Arun District Conservation Area Advisory Panel
c/o Civic Centre

Application No: BR/147/20/PL

Site Address: 53 High Street Bognor Regis PO21 1RX

Description of works: Conversion of first & second floor & rear extension to create 4 No. 1-bed self-contained flats including the demolition of existing rear extension & erection of two storey rear extension. This application may affect the setting of a listed building & may affect the character & appearance of The Steyne, Bognor Regis Conservation Area. This application is in Cil Zone 4 (Zero Rated) as flats.

Proposed Front
Elevation
Scale 1:100

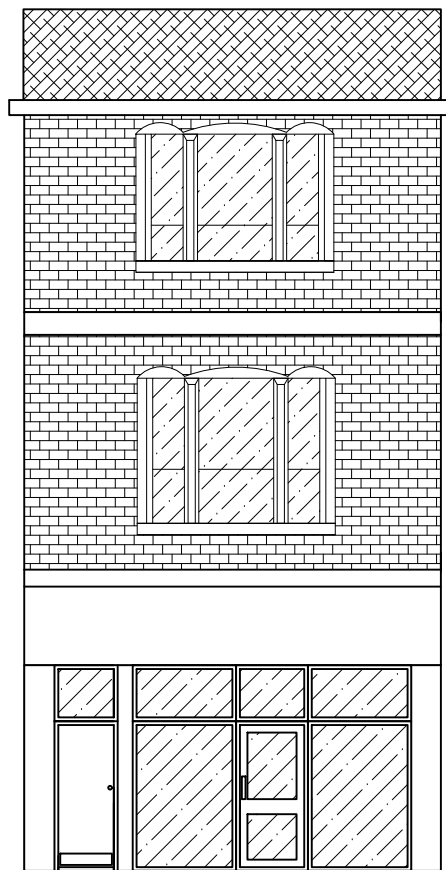
53 High Street is a Victorian building in the centre of town with frontage which has been a retail shop and storage space above it. It has attractive windows to the upper floors which are to remain timber framed, the retail space will be refitted and a new supplementary door will be added to allow access to the flats. To the rear, the building faces onto a 5 storey block of flats with the rear of other buildings also fronting the High Street providing an uninspiring street scene.

It is regretted that the renovated shop frontage will be aluminium powder coated and not pick up the style and materials of the original building but there are other similar shop frontages close by and the panel cannot see that this will sway planning officers.
